**KIRKLEES METROPOLITAN COUNCIL
INVESTMENT & REGENERATION SERVICE**

**DELEGATED DECISION FOR APPLICATION FOR CERTIFICATE OF
LAWFUL DEVELOPMENT**

Reference no.: 2025/CL/90807/E

Site: 28, Clarke Street, Westborough, Dewsbury, WF13
4LR

front elevation

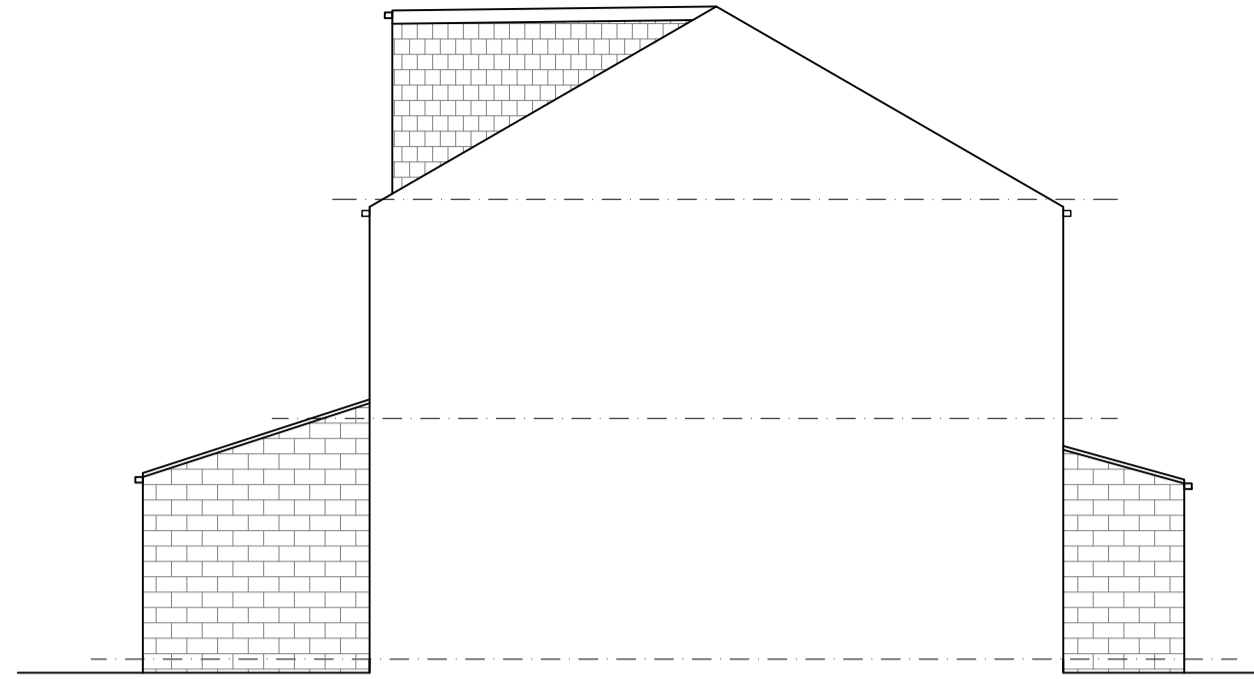
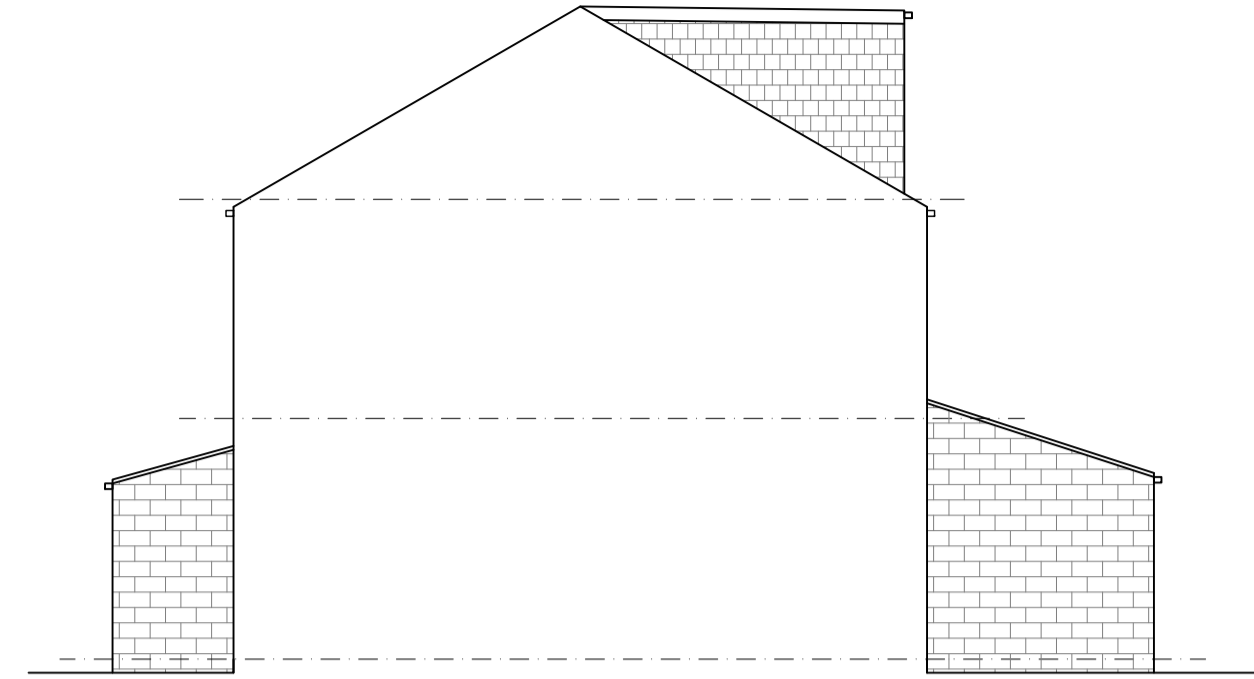
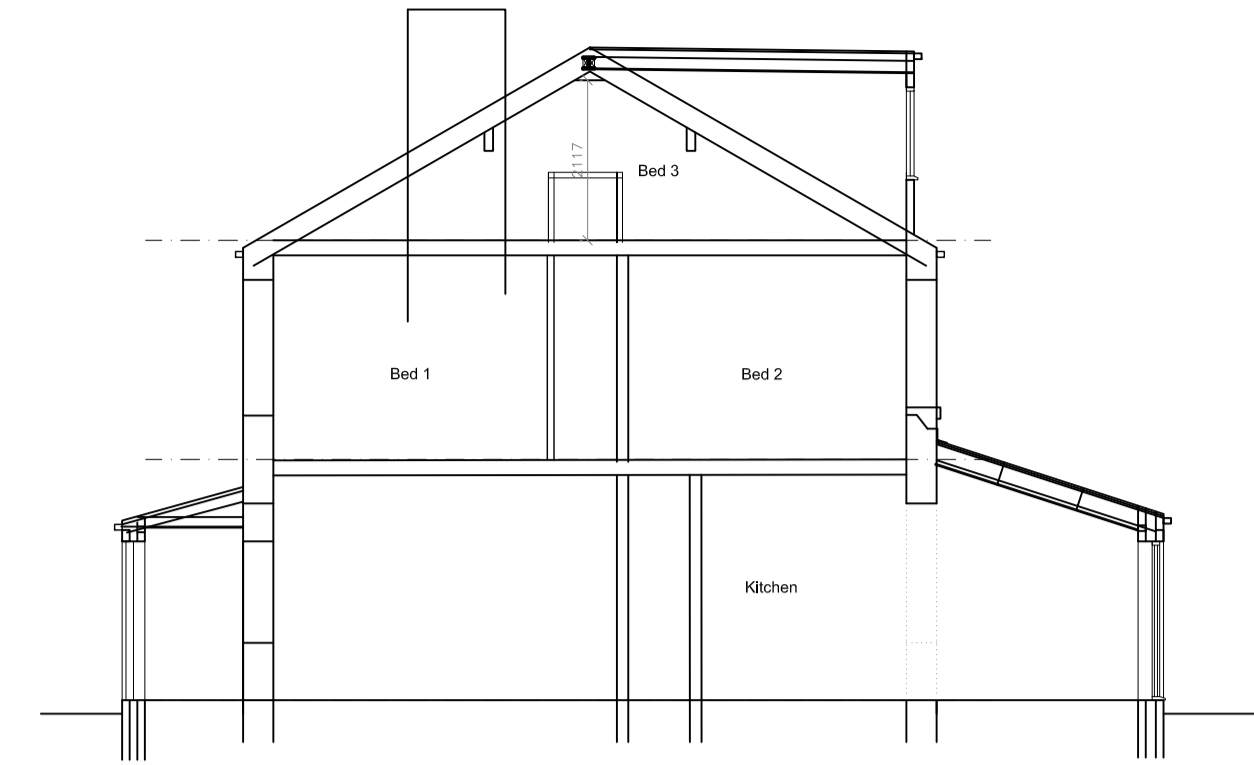
Comment: The dwelling is a terraced property, and the extension would project beyond the rear wall of the original dwellinghouse by 3 metres.

Comment: The dwelling is a terraced property, and the extension would project beyond the rear wall of the original dwellinghouse by 3 metres. It would not exceed 4 metres in height. The matter to be assessed has been submitted for a Lawful Development Certificate and not a prior approval for a larger householder extension.

Comment: The extension is within 2 metres of the boundary of the curtilage of the dwellinghouse but does not exceed 3 metres in height.

Comment: As a terrace property, the maximum additional roof volume permitted is 40 cubic metres. The resulting roof space created by the rear dormer would not exceed 40 cubic metres.

Ground floor plan

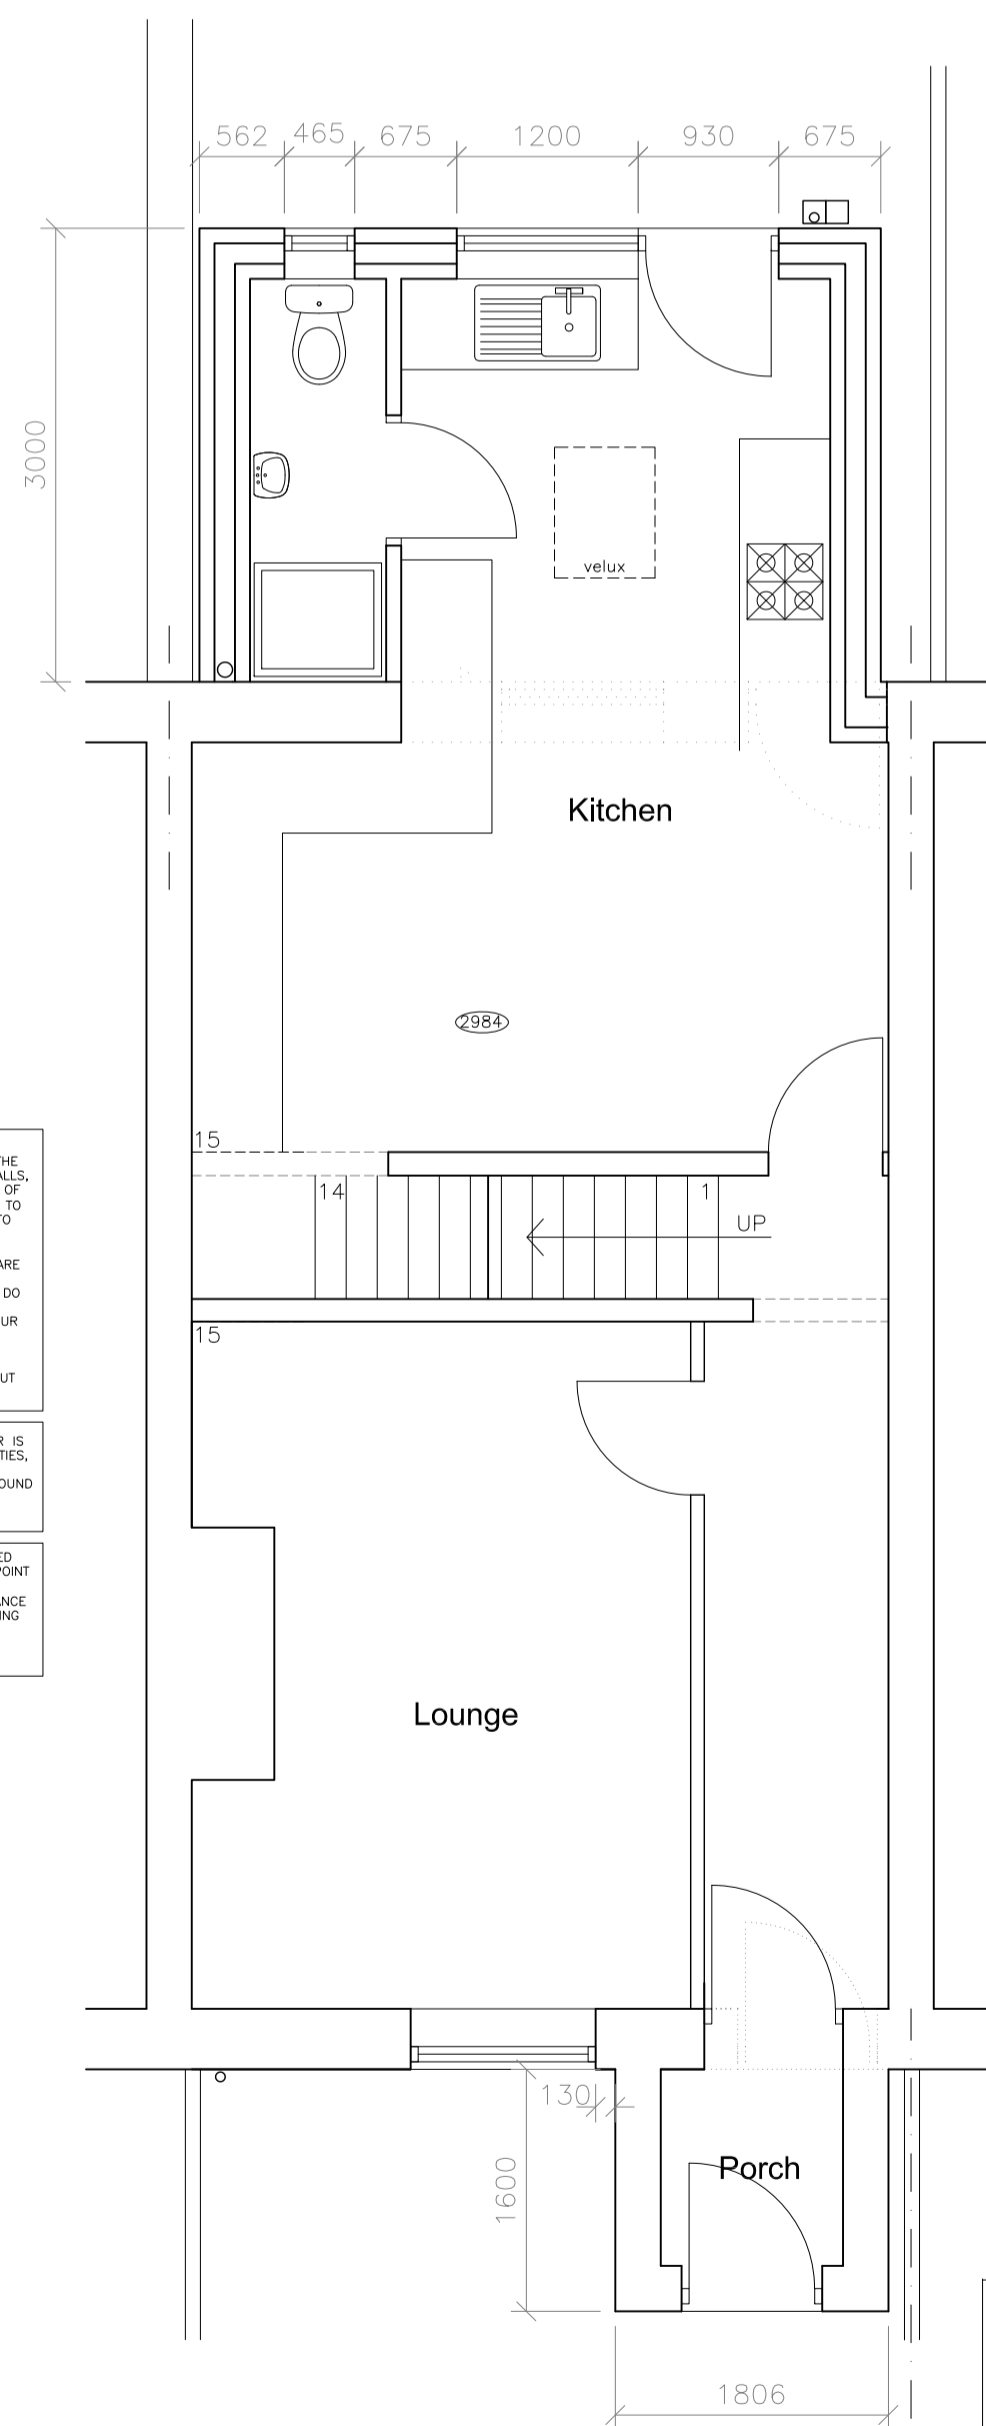
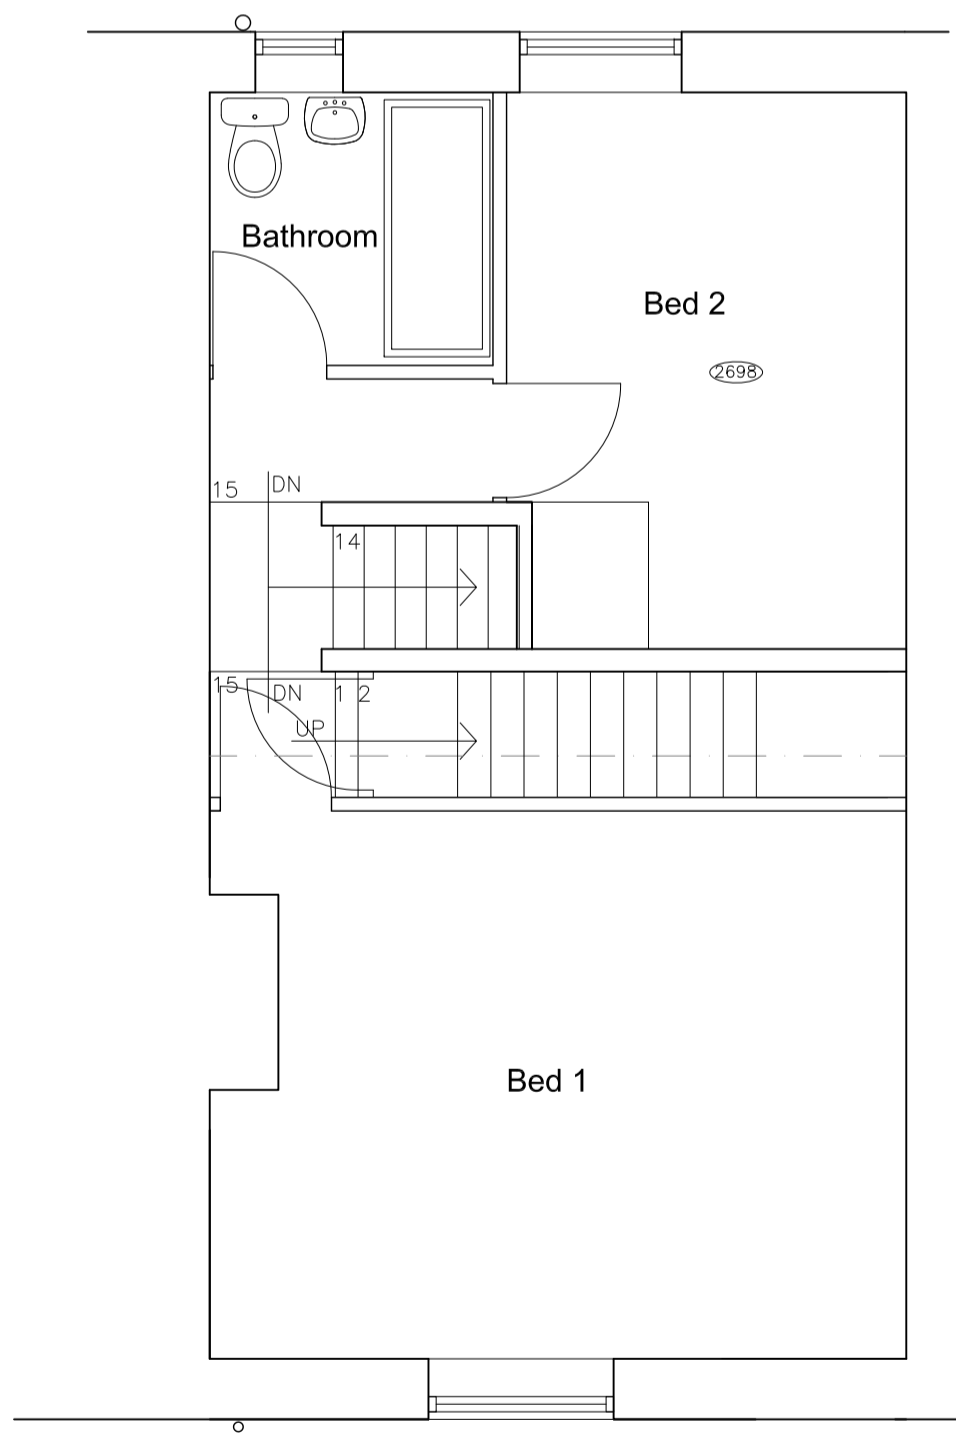
Comment: The ground area of the porch when measured externally would not exceed 3 square metres.

Comment: The maximum height of the porch would not exceed 3m.
